**Lindfield Learning Village Phases 2 and 3 (partial SSD 8114)
– Response to Submissions**

TAB A Detailed comments on (partial) SSD 8114 Traffic and Transport Assessment – Response to Submission Report

TITLE
INDICATIVE CONSTRUCTION MANAGEMENT PLAN

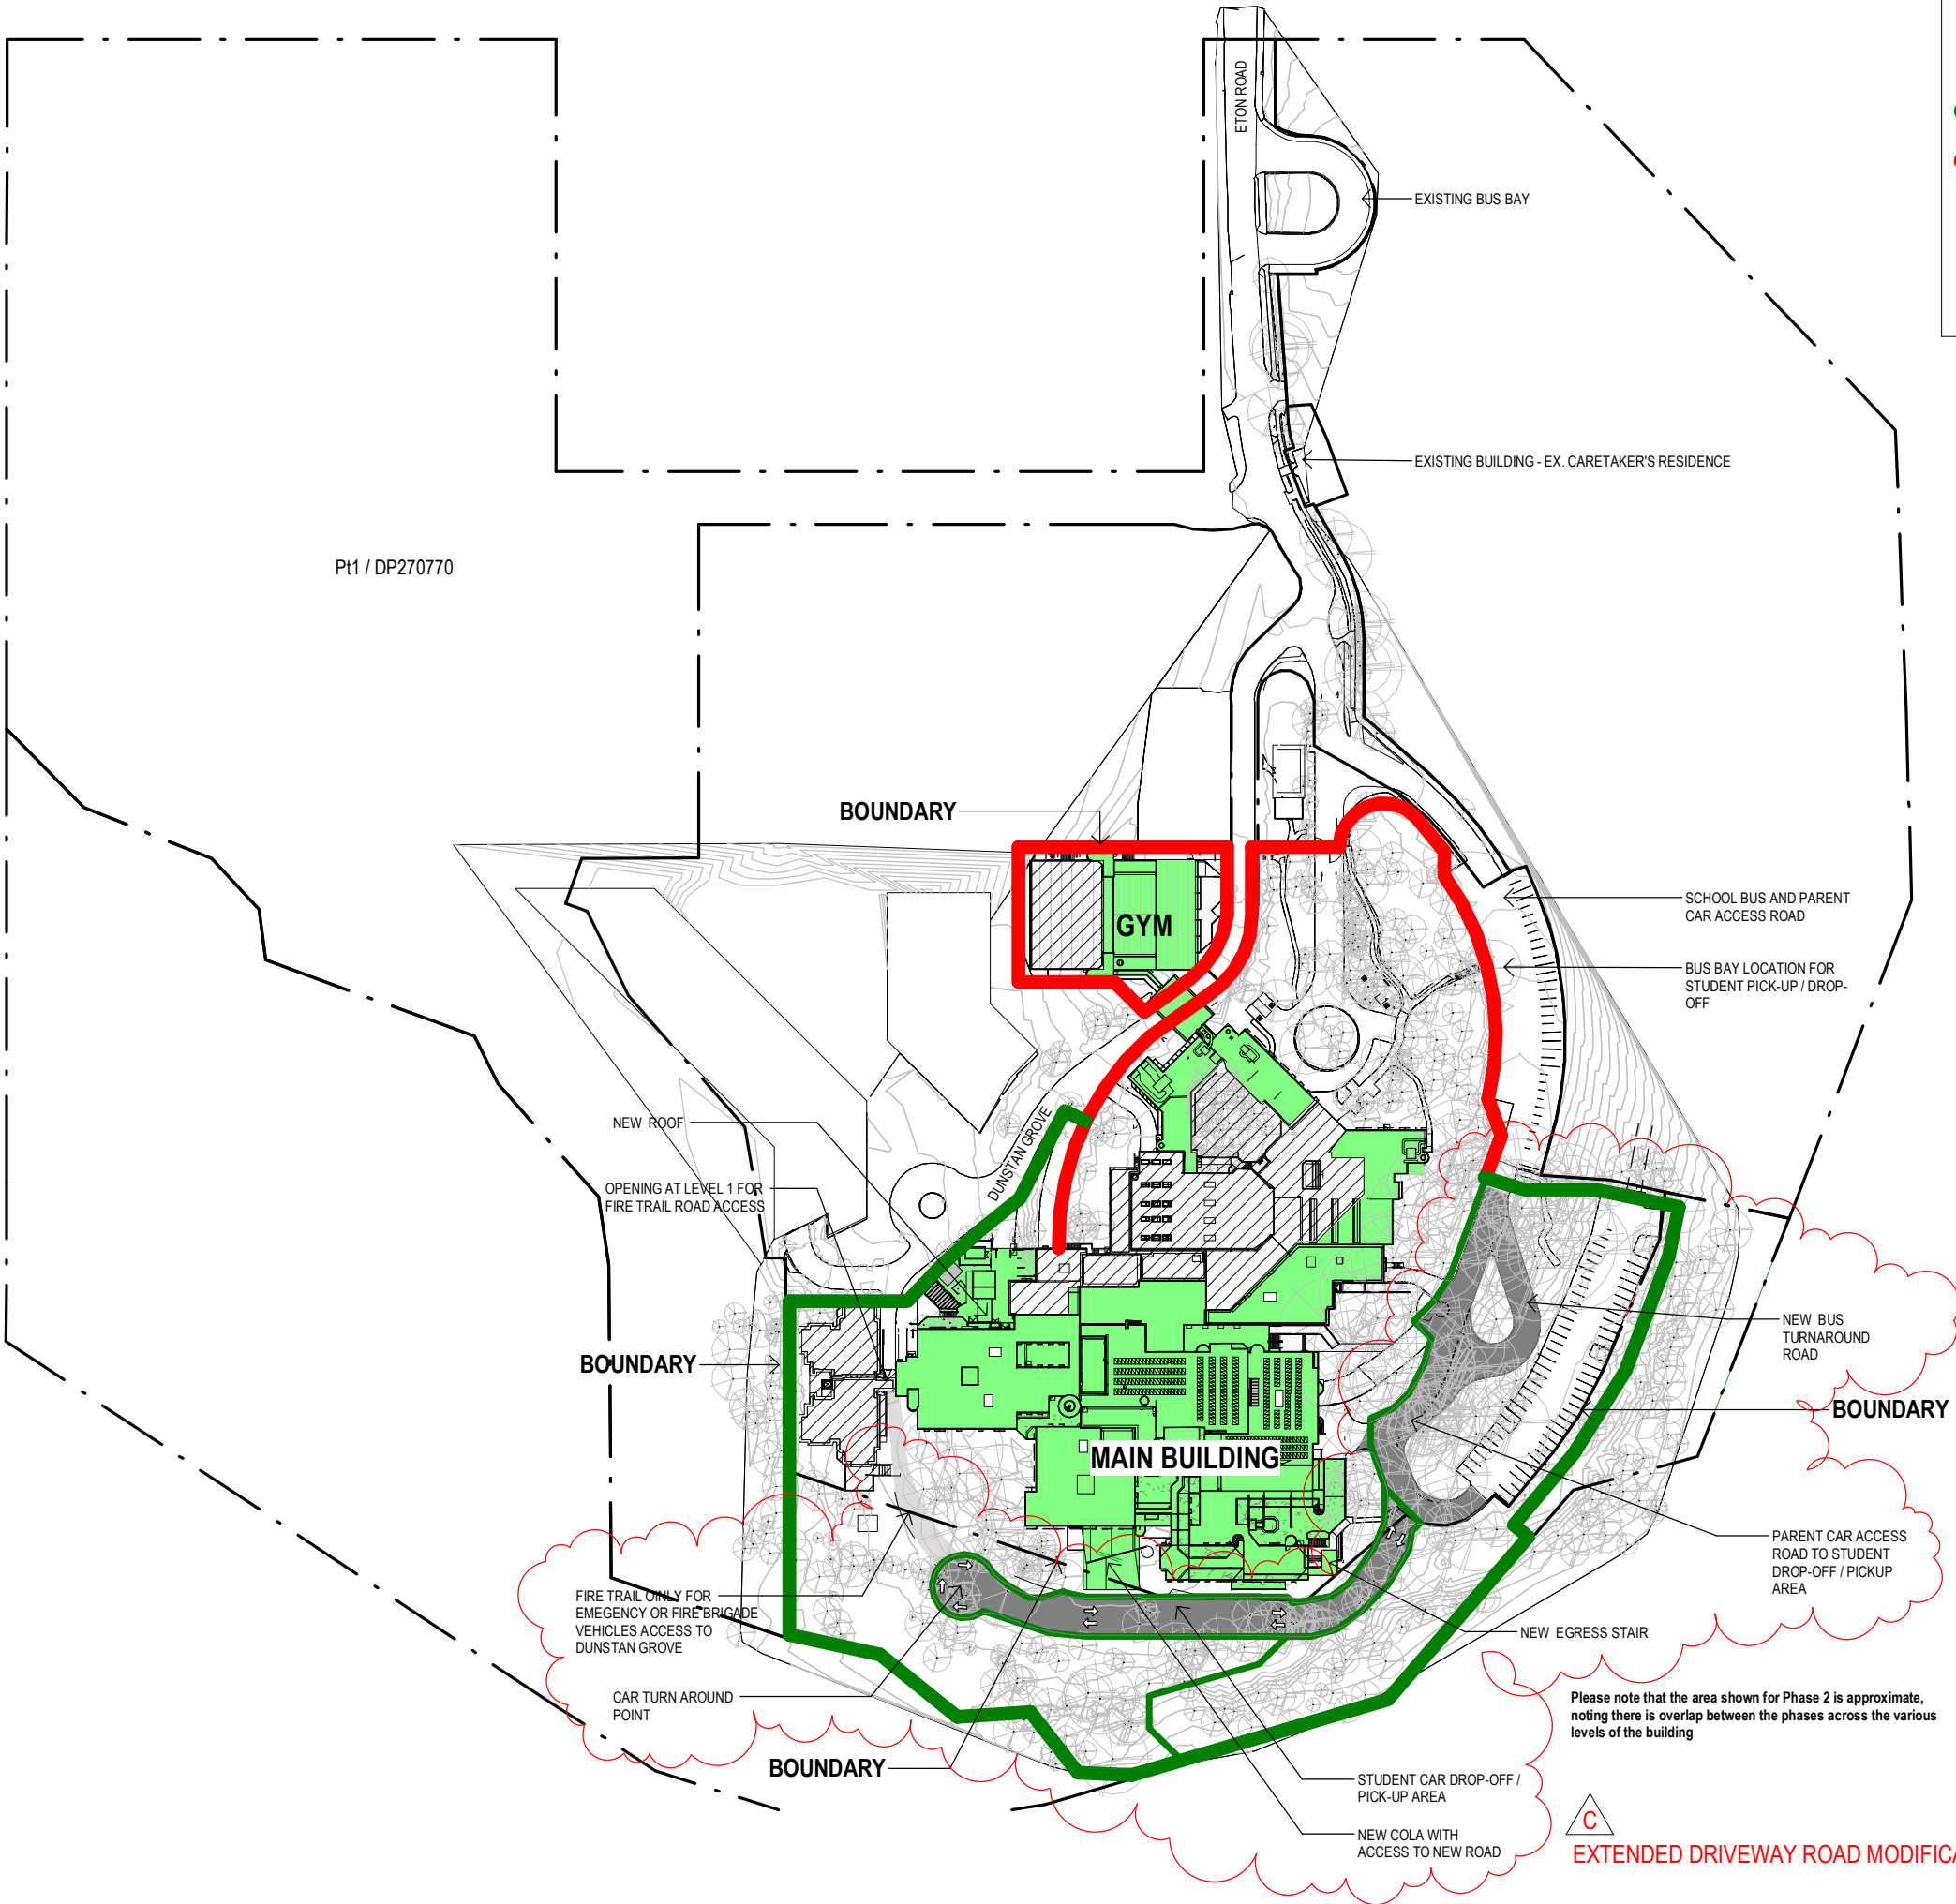
A drawing titled “Indicative Construction Management Plan” is provided in Appendix Q of the Response to Submission Report, noting that a set of Construction Traffic Management Plan Notes is included in this drawing. The aforesaid notes indicate that vehicular access to and from the site would be from Dunstan Grove.

As the existing Phase 1 will continue in operation while the construction occurs, truck movements should not be carried out during school DOPU times (unless otherwise approved) and no truck queuing should be permitted on public streets that would affect the general traffic and public transport operation. Construction site access should also give consideration to the operation of car park and DOPU areas where pedestrian and road safety would be a concern.

A detailed Construction Pedestrian and Traffic Management Plan for various construction stages detailing construction vehicle routes, number of trucks, hours of operation, access arrangements and traffic control should be prepared in consultation with the local council and TfNSW and submitted to the relevant consent authority for approval prior to the issue of a Construction Certificate.
